Case Officer: Shona King

Proposal: Discharge of Conditions 2 (Schedule of materials), 3 (Samples of slate), 4 (stone sample panel), 6 (doors & windows), 7 (gable dormer details), 8 (ridge architectural details) and 11 (location of bat boxes) of 21/01254/REM

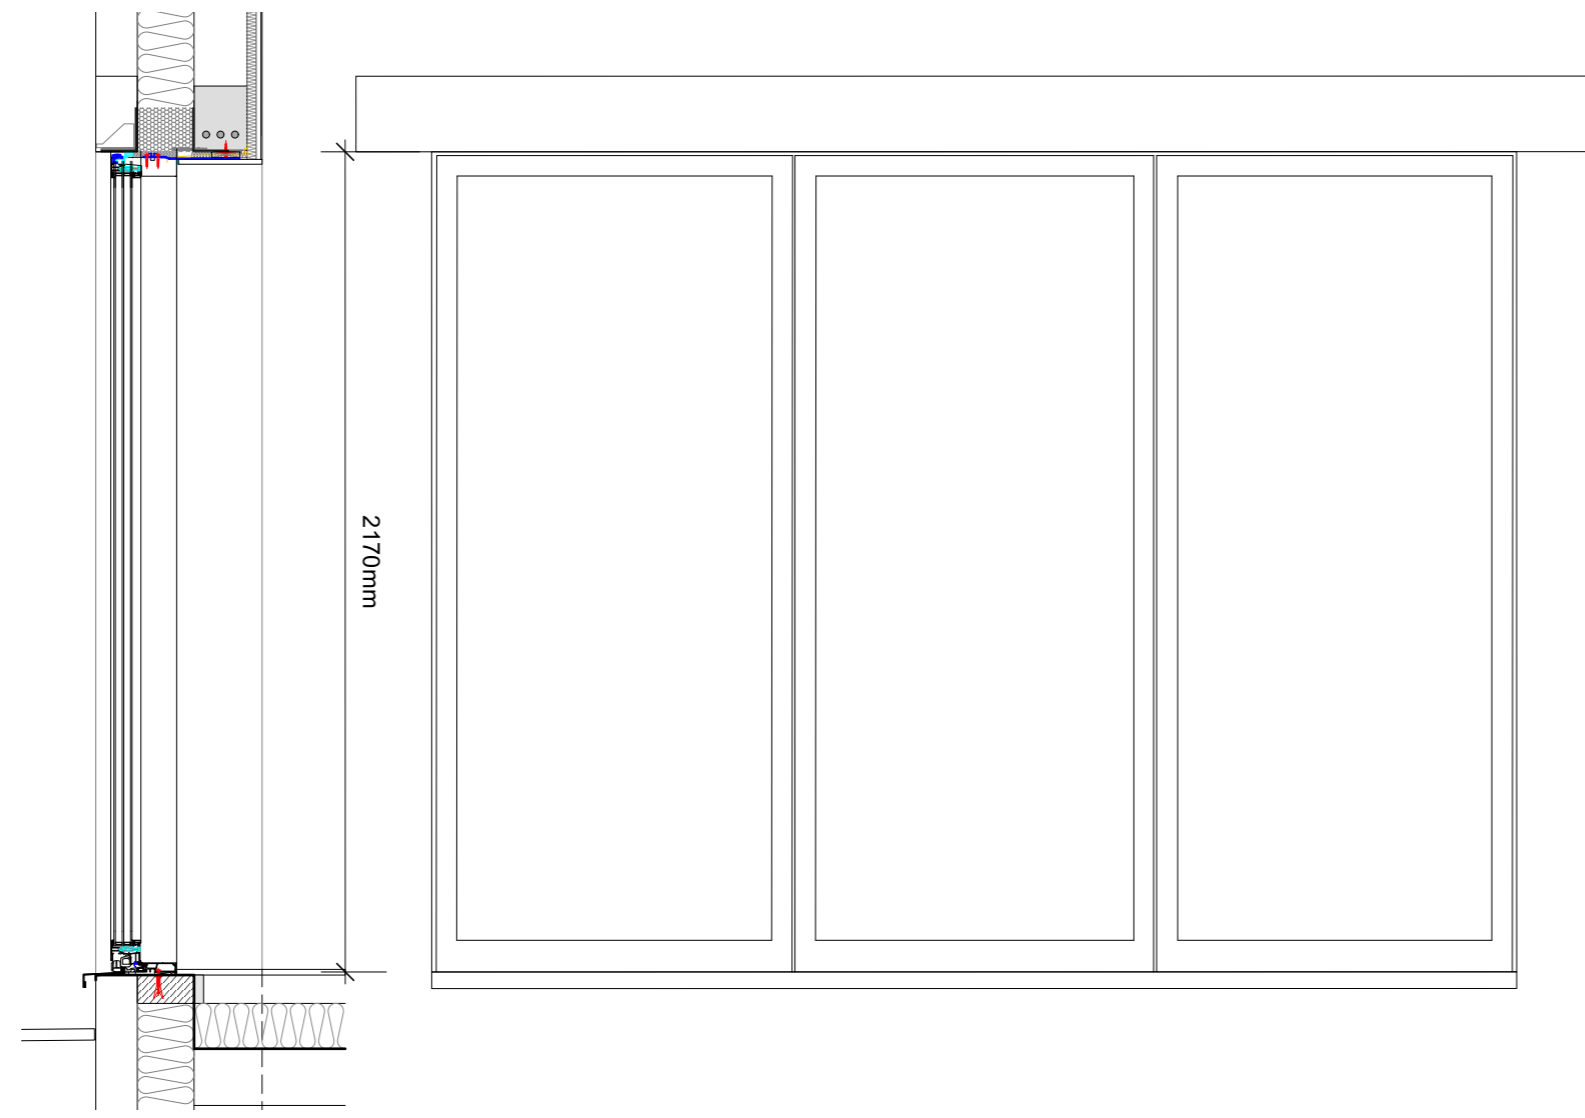
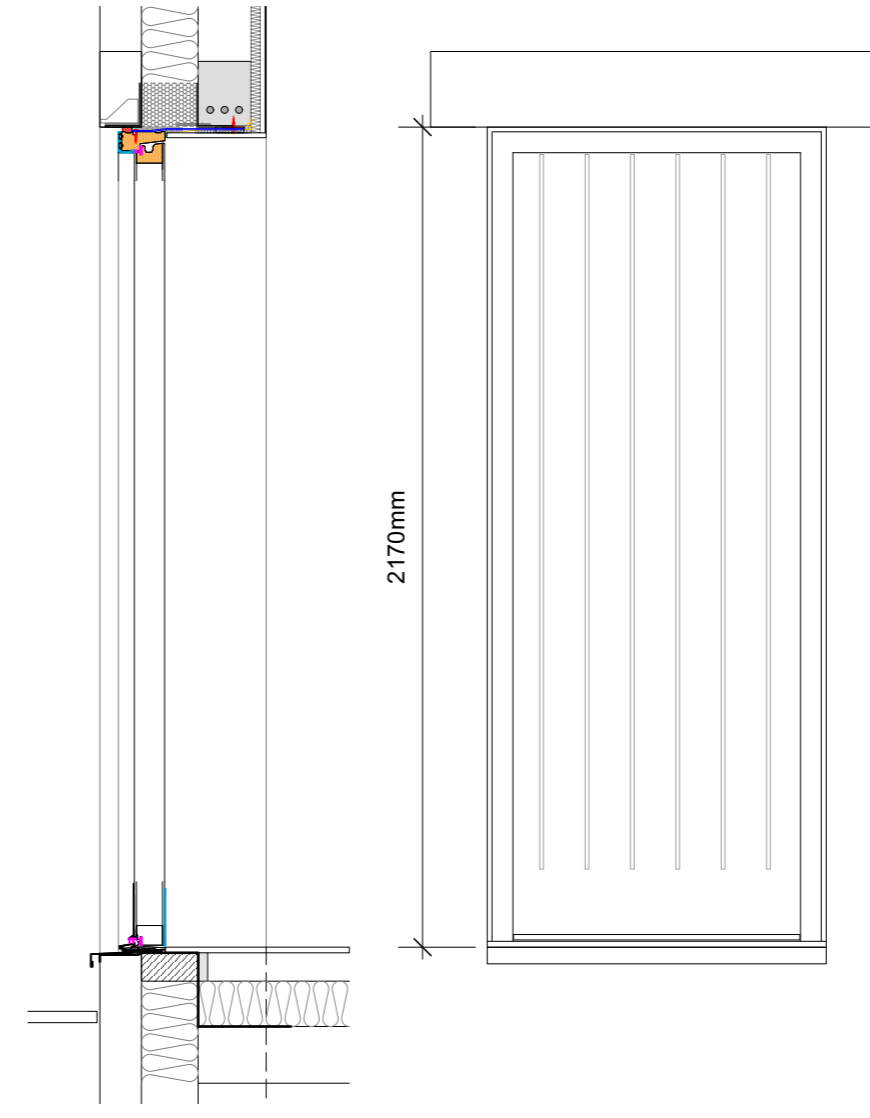
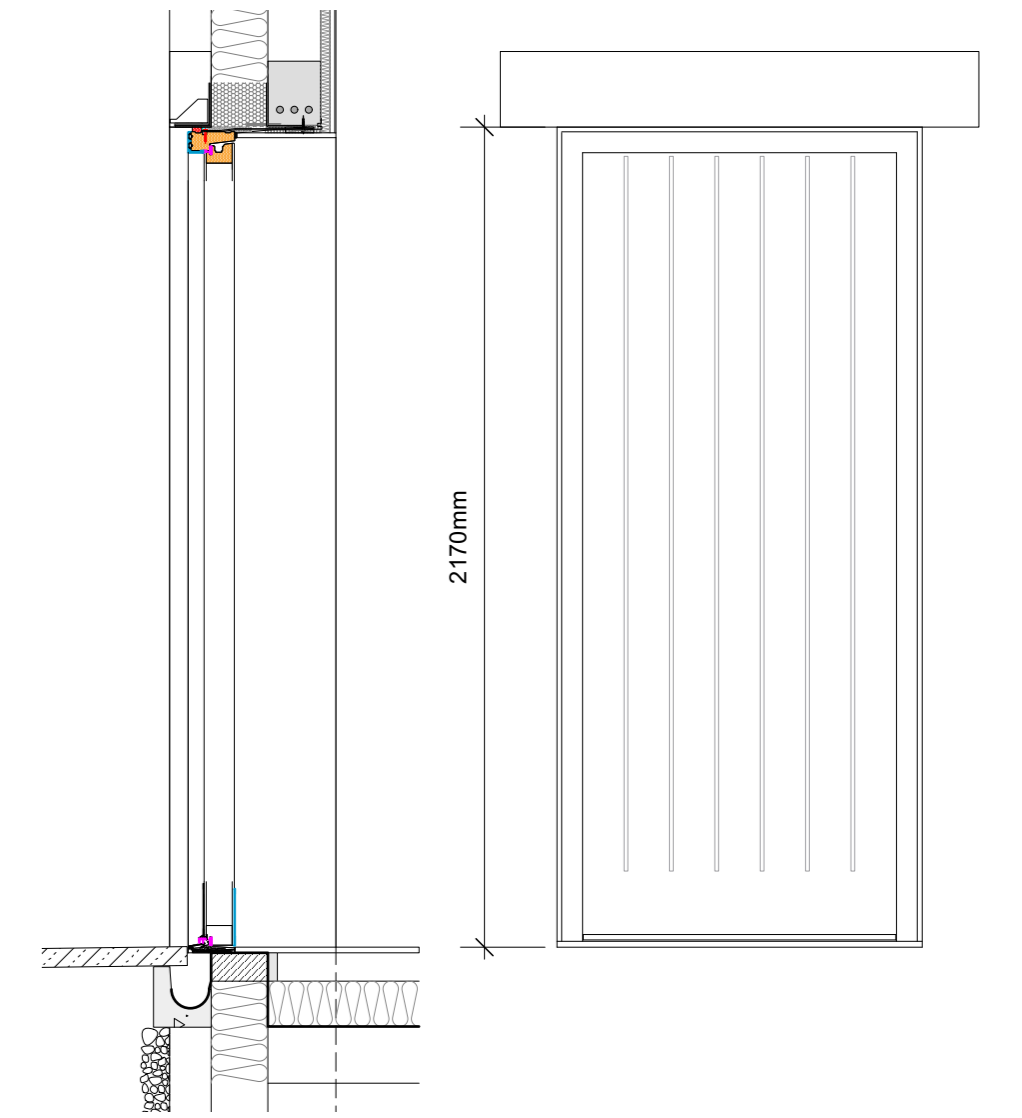
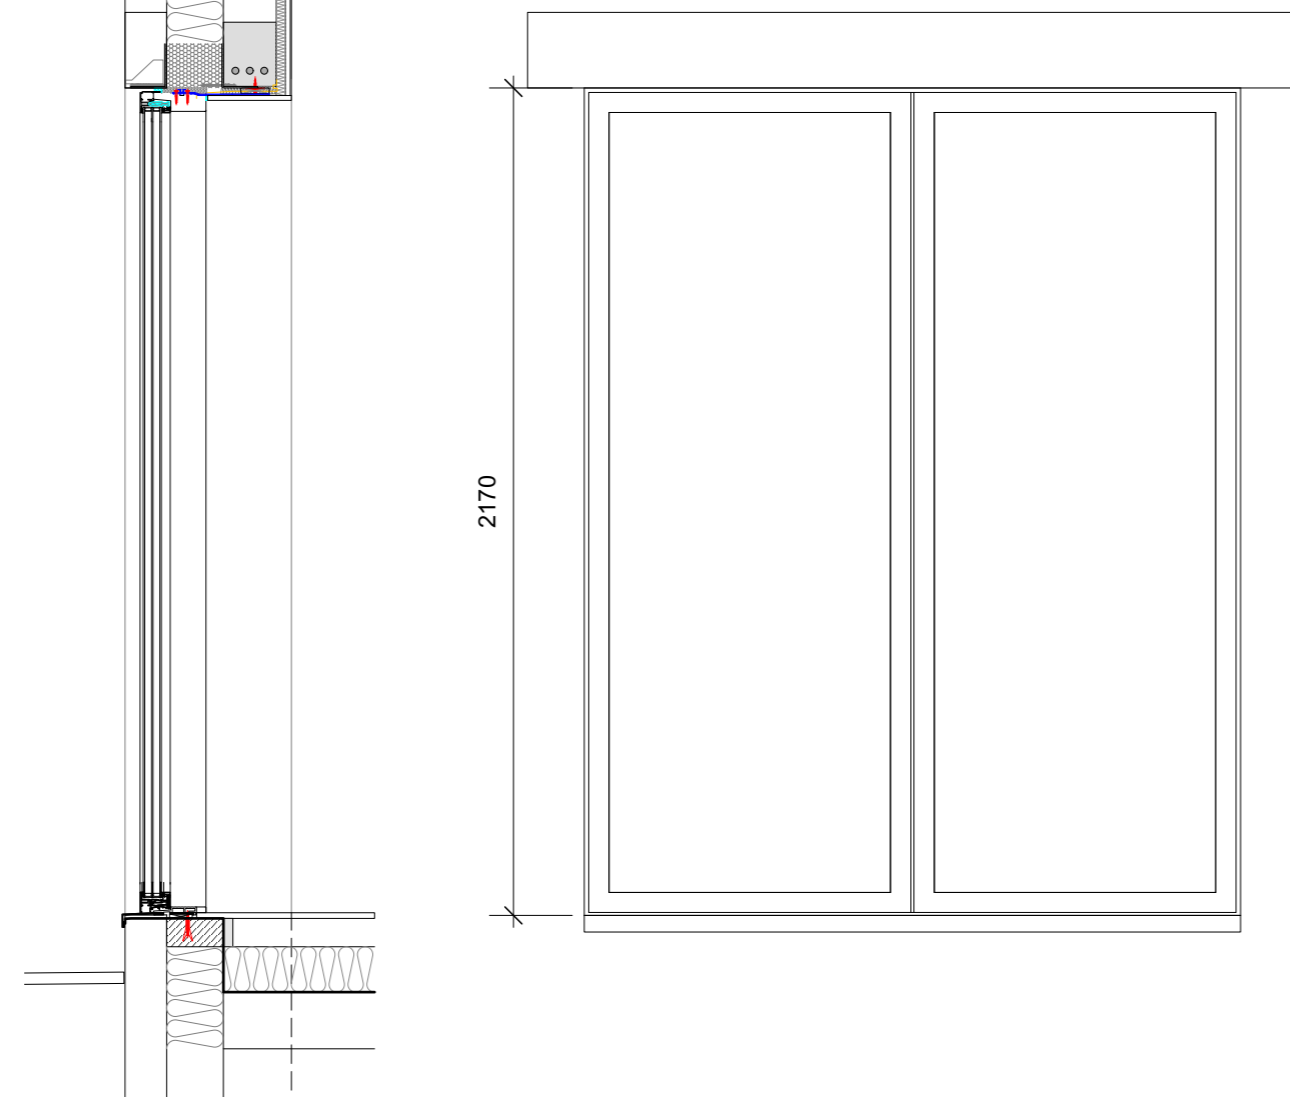
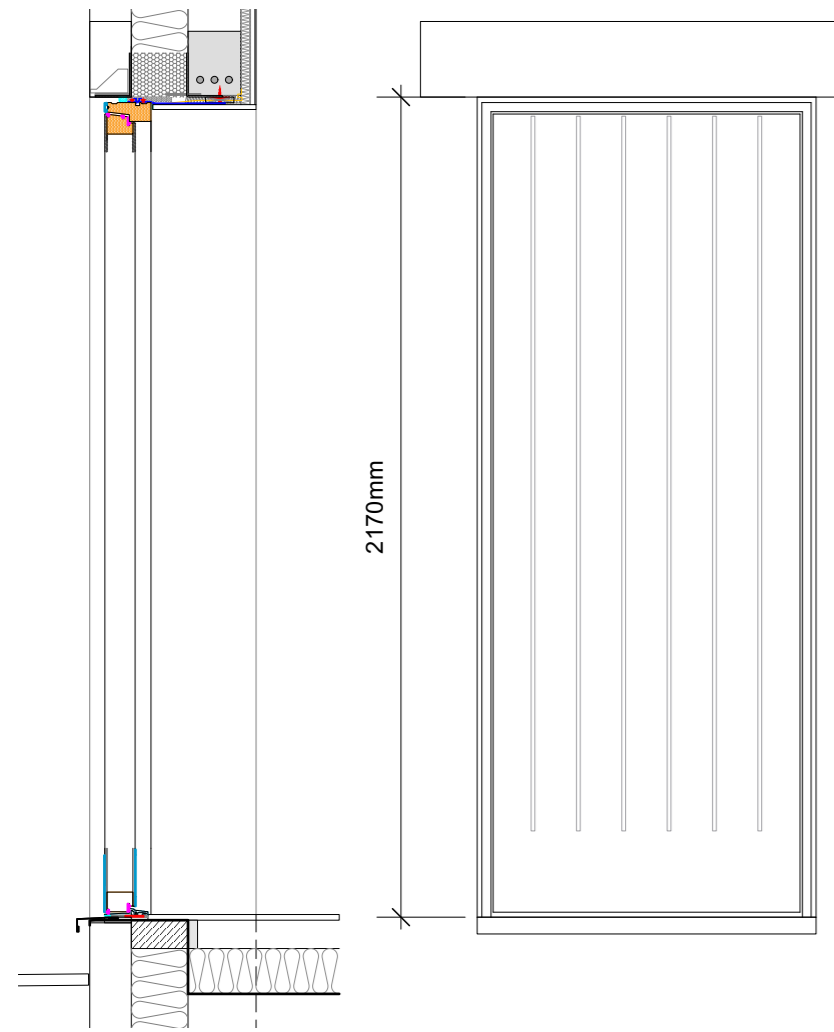
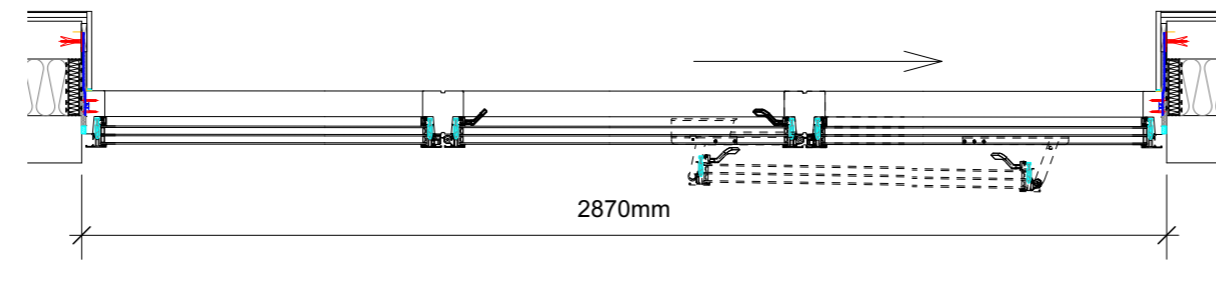
- 5.4. Condition 6 requires the approval of details of the doors and windows. The details that have been submitted are considered to be acceptable.
- 5.5. Condition 7 requires the approval of details of the gabled dormer. The details that have been submitted are considered to be acceptable.
- 5.6. Condition 8 requires the approval of the architectural detailing of the ridge and treatment of the eaves and verges. The details that have been submitted are considered to be acceptable.
- 5.7. Condition 11 requires the approval of a scheme for the location of bat boxes. The proposed bat boxes are suitable for the species found foraging and roosting and should constitute an enhancement in opportunities on site.

Condition 6

Drawing Nos: 21.02.04.22, 21.02.04.23 and 21.02.04.24
